Silverleaf Solar Farm (SSD-9358) – Response to RFI-39195709

**Attachment 1 – Updated intersection design including Basic
Left Turn (BAL)**

Client	NSW GOVERNMENT
Project	NARRABRI SOLAR FARM SILVERLEAF
Title	KAMILAROI HIGHWAY / LOGANS LANE INTERSECTION UPDGRADE - BAR ONLY OPTION
Original Size	A1
Drawing No:	22-12518304-SK003
Rev:	C

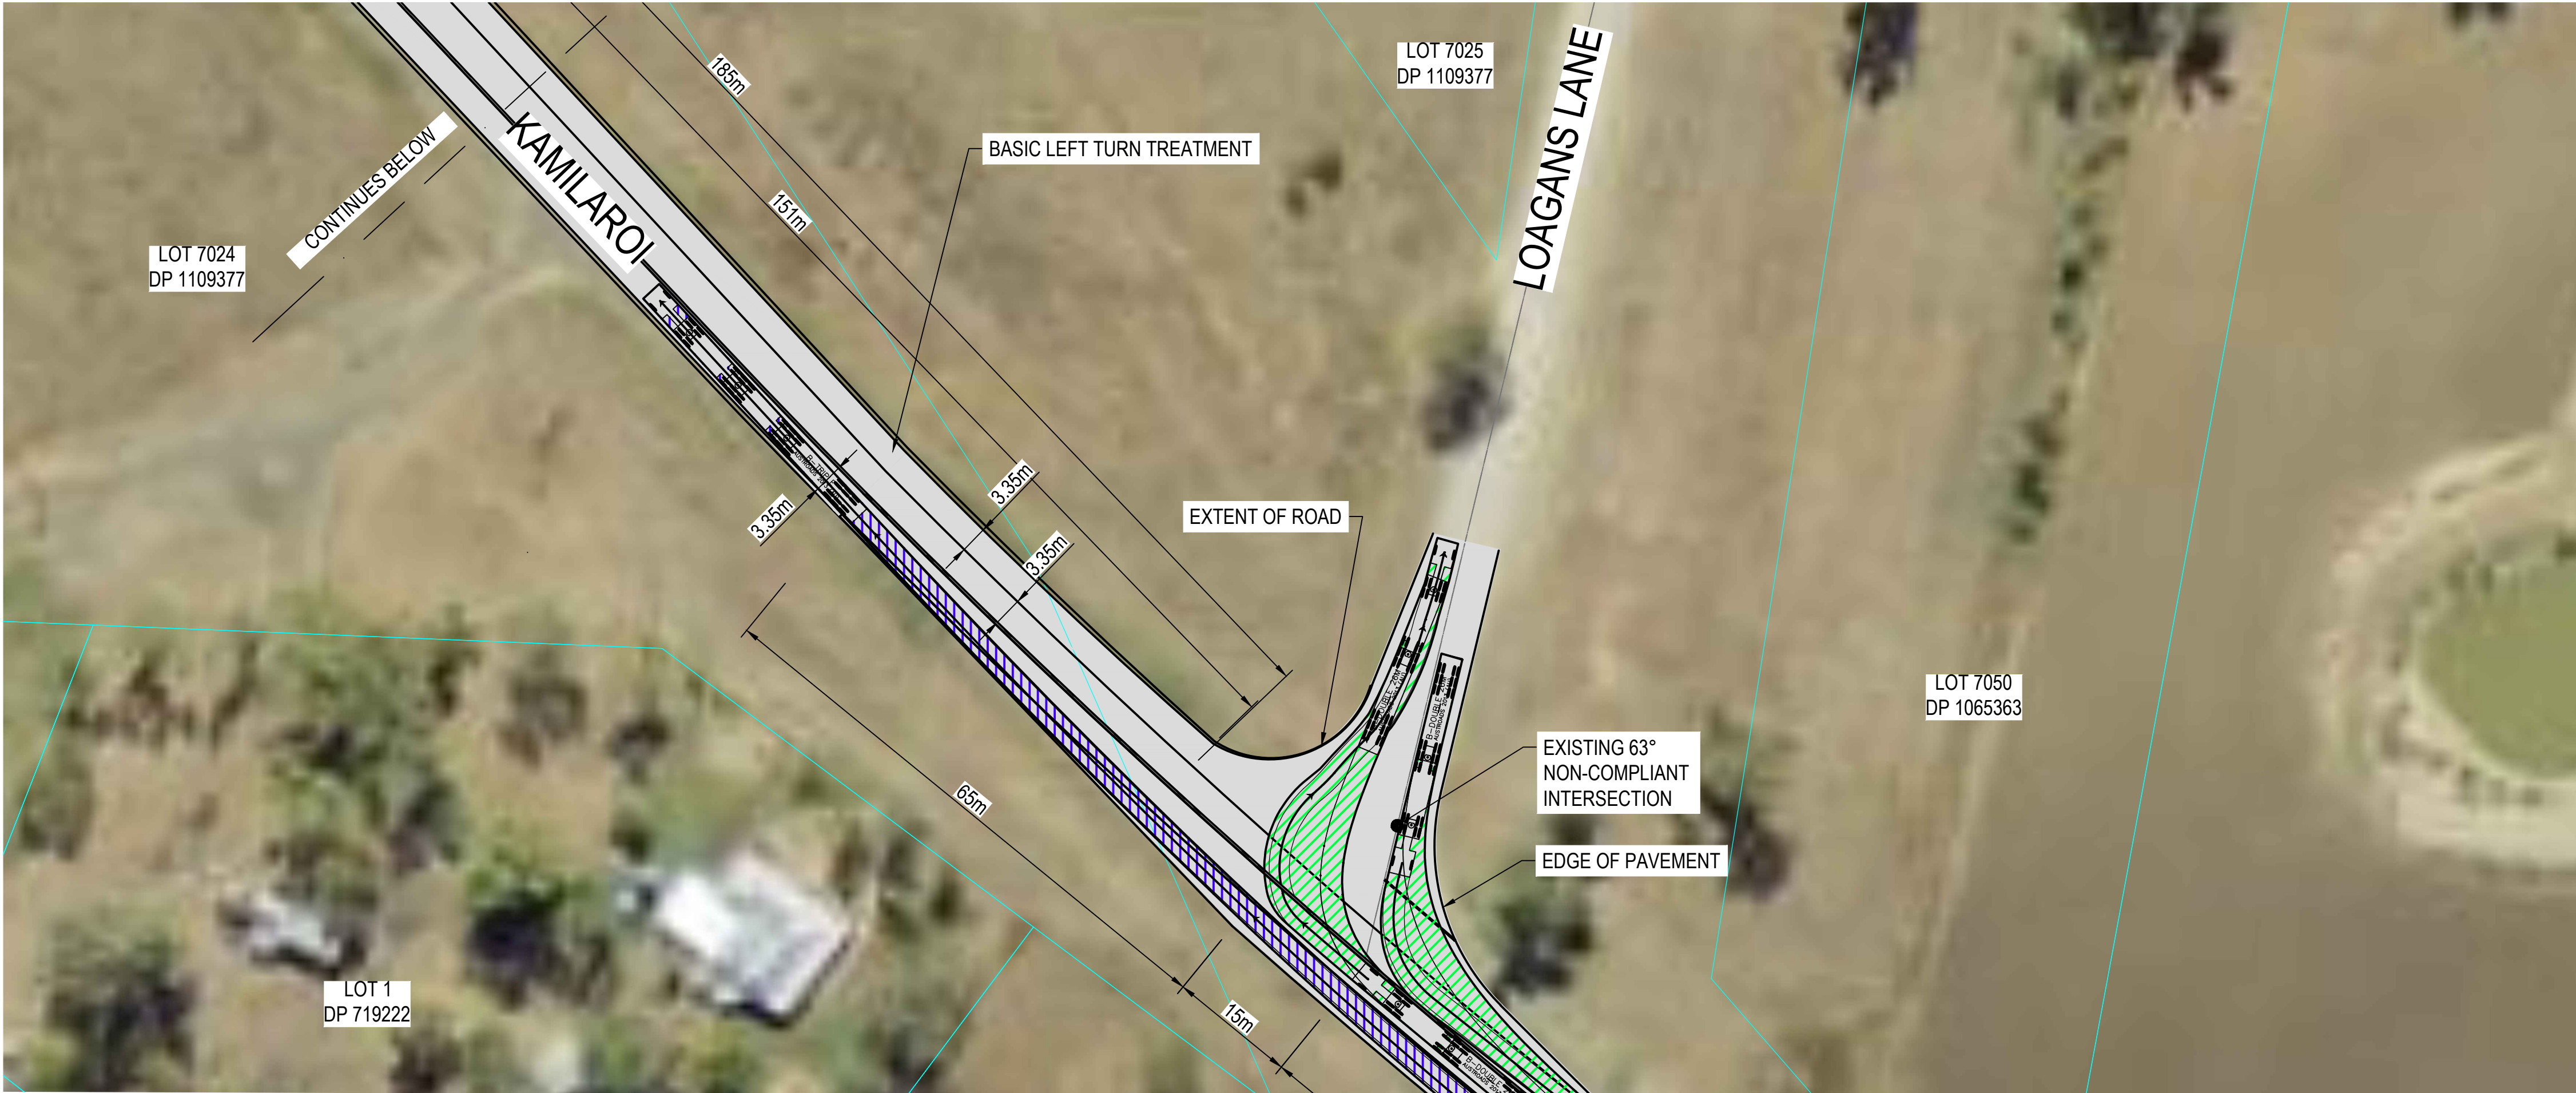
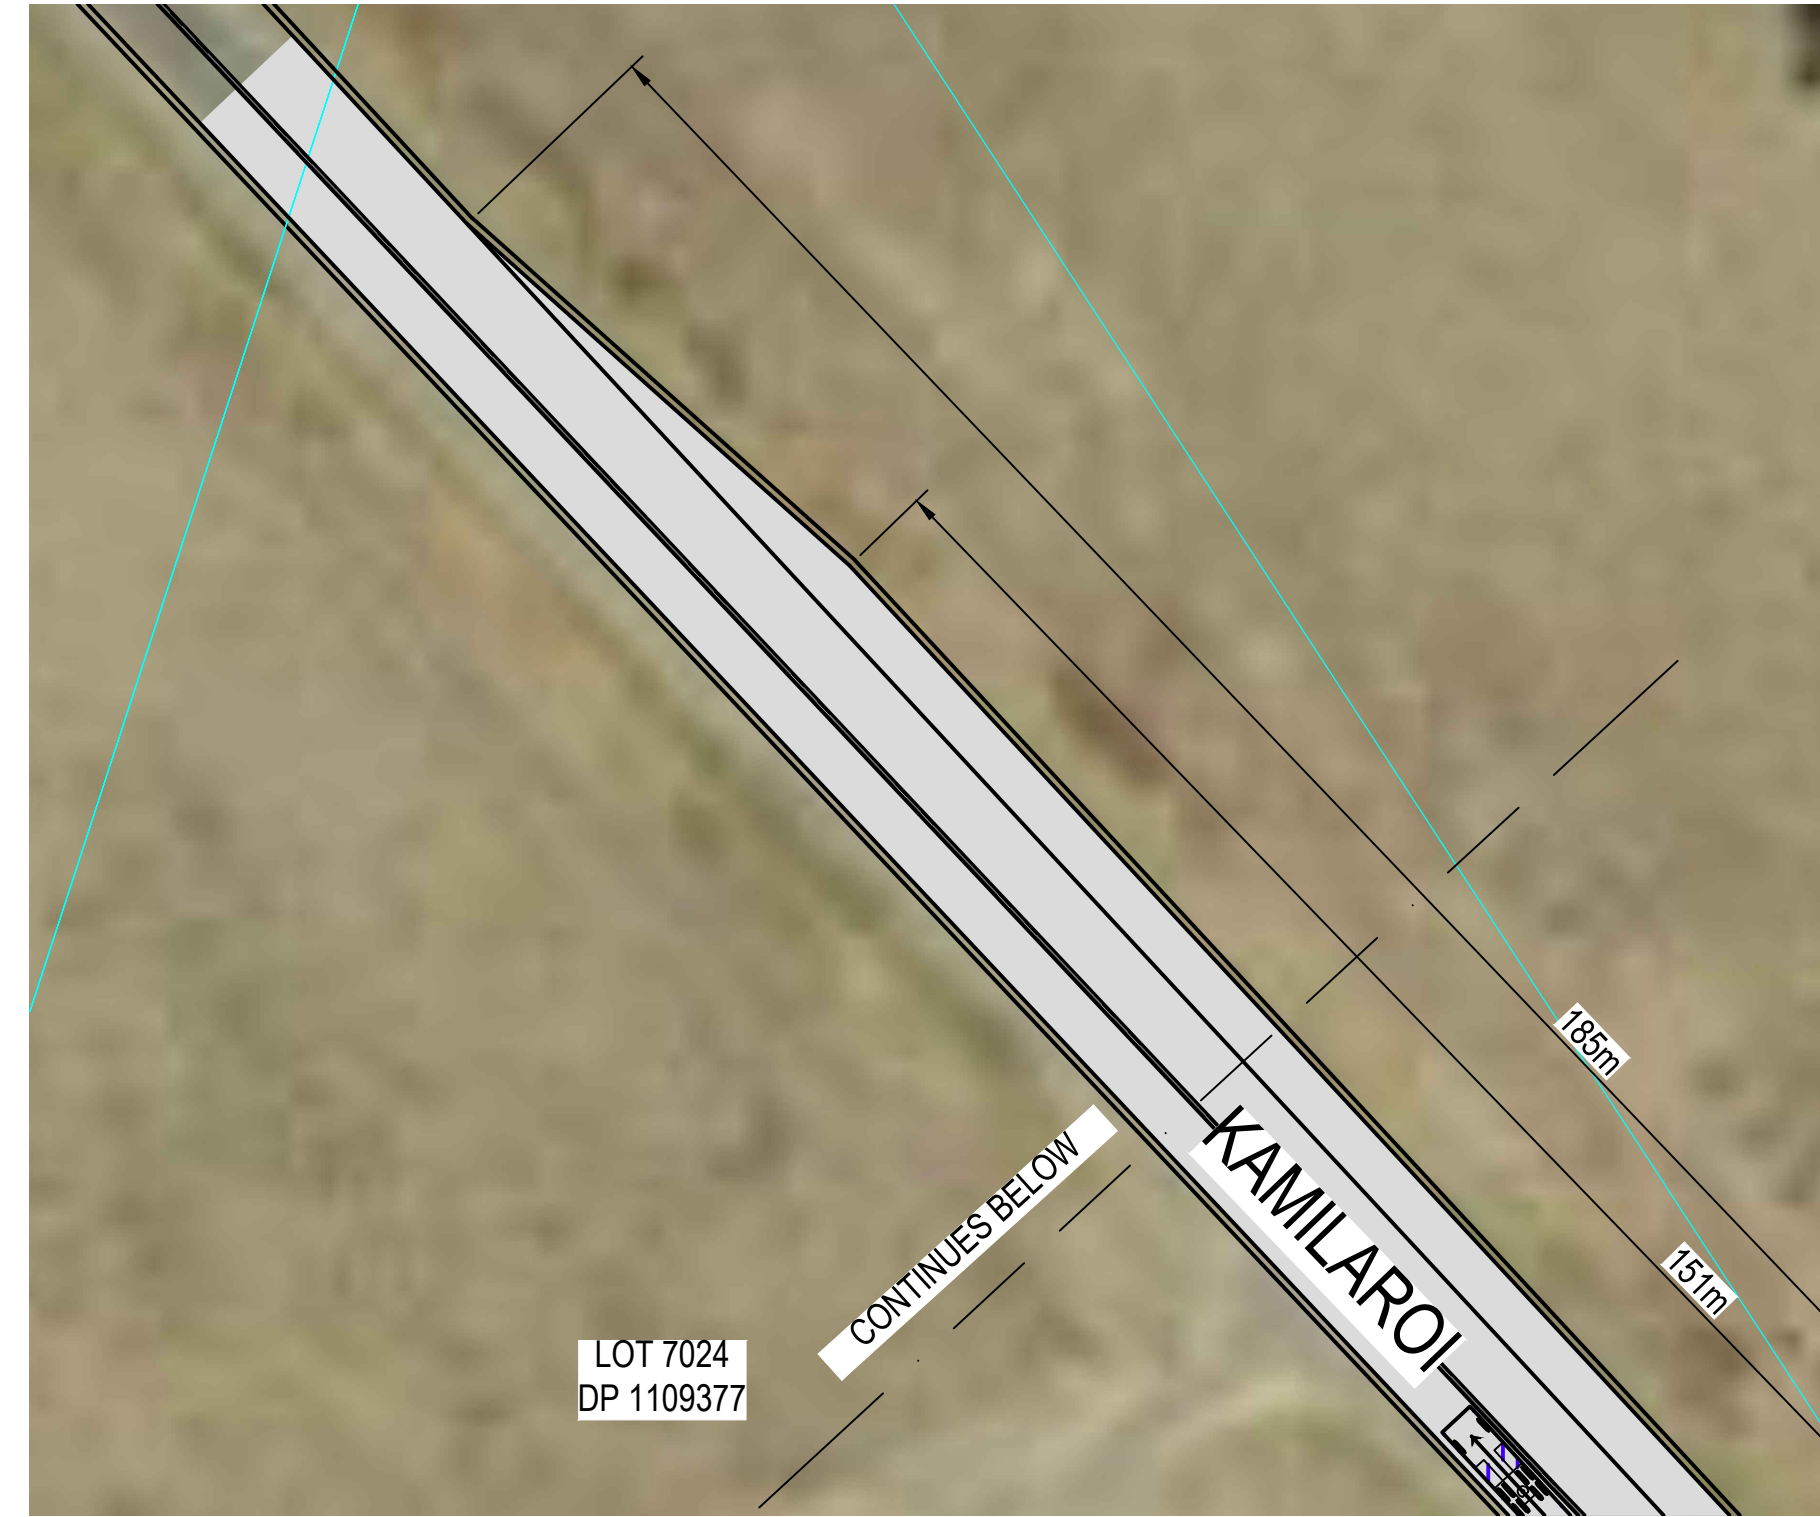
- Has revised drawings for the treatment of intersection of Kamilaroi Highway and Logans Lane, incorporating a Basic Left Turn (BAL) treatment (Attachment 1).
- Confirm that this revised intersection treatment will not have additional impacts on native vegetation or heritage.
